**Ref No:** F2021/00252

Application No: SSD-8706

**Re: Randwick City Council Response to Submissions on the State Significant Development SSD-8706 – Night Racing at Royal Randwick Racecourse (SSD-8706)**

Figure 1 Site Plan

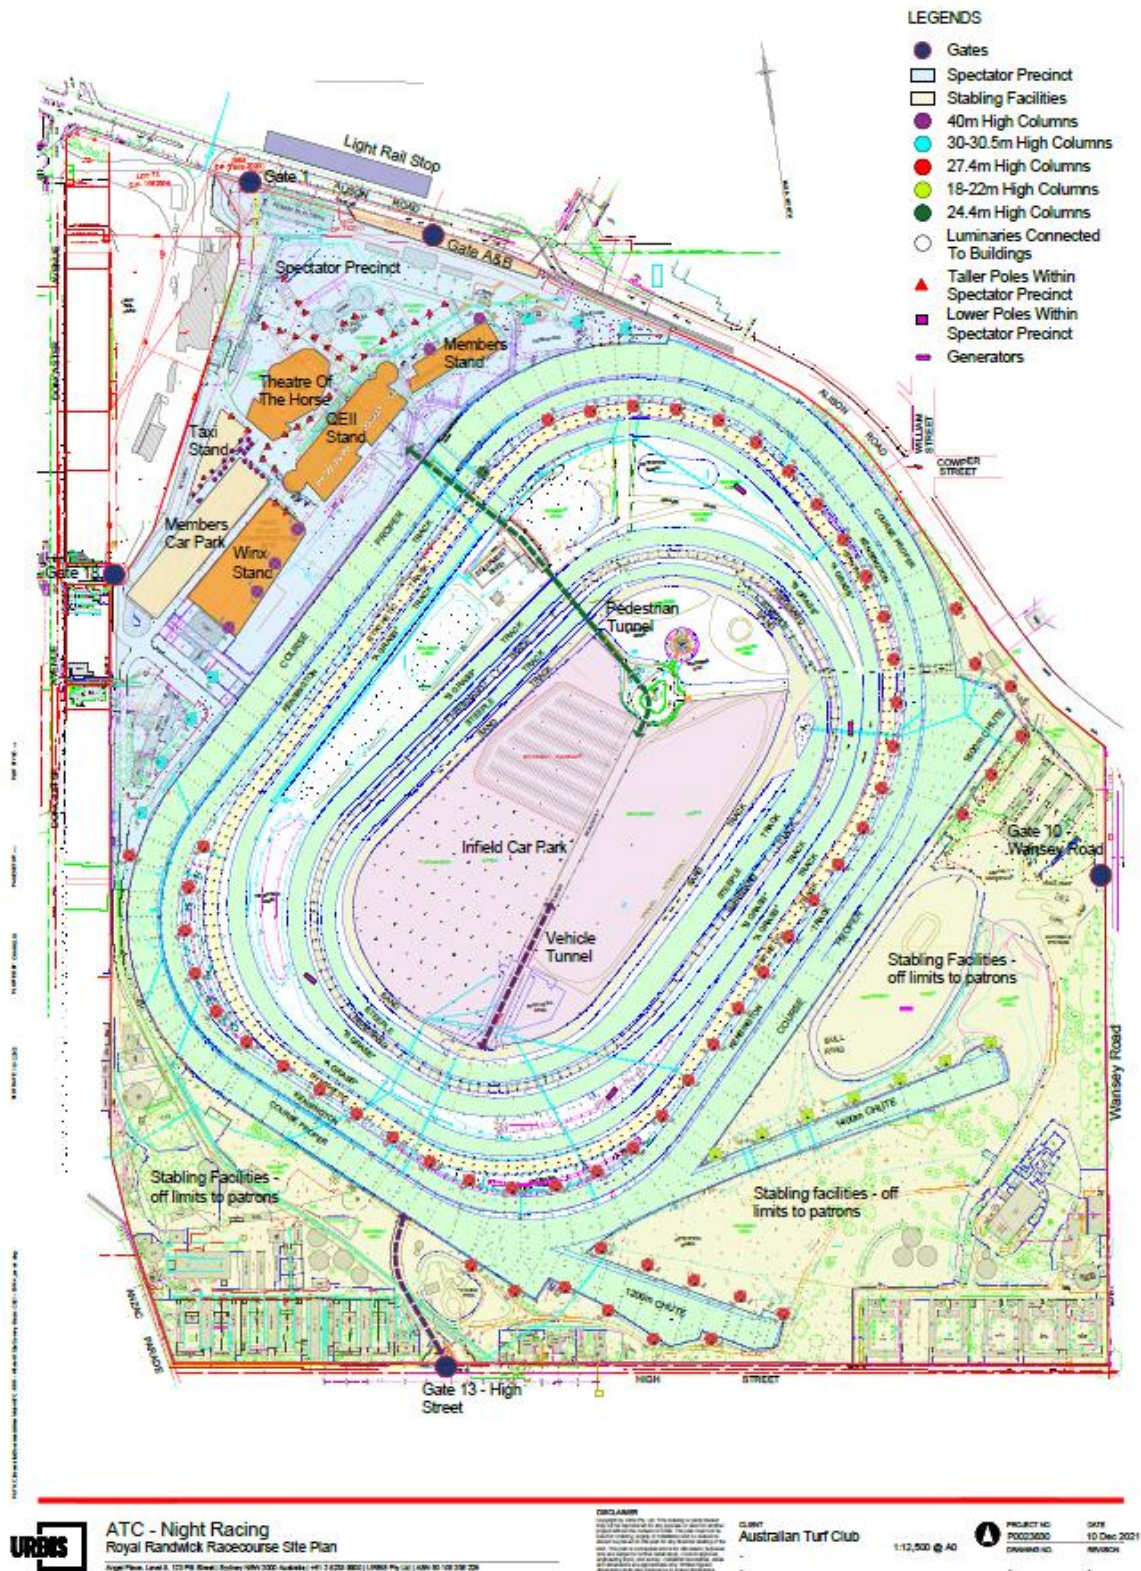
In relation to discrepancies in drawings, the Site Plan submitted as part of the RtS documentation indicates the following:

- 40m high light columns behind the Members Stand and attached to the Winx Stand
- 30-30.5m light columns to the east of the Members Stand and to the south of the Winx Stand
- 27.4m high light columns encircling the track and adjacent to the 1200m chute
- 18-22m high columns adjacent to the 1400m chute
- 24.4m high light columns (one only) on the track in front of the QEII Stand
- Some of the light poles will have two tiers of lights, one at the top and another further down the pole.

Once again, the Site Plan does not indicate significant trees on the site, including a number within the Spectator Precinct in close proximity to light columns. The Site Plan key also indicates taller poles within the Spectator Precinct (mostly behind the Members Stand and the Theatre of the Horse) and lower poles within the Spectator Precinct (adjacent to the Members carpark and the taxi stand). It is unclear whether these taller and lower poles are new or existing. Similarly, no information is provided on the height of these poles. The Light Pole Elevations drawing does indicate some poles which are 18.75m high and some which are 21.43m high. It is assumed that the taller and lower poles within the Spectator Precinct are either 18m or 21m high. It is noted however that the previous submission noted pole mounted LED lighting up to 10m in height within the Spectator Precinct.
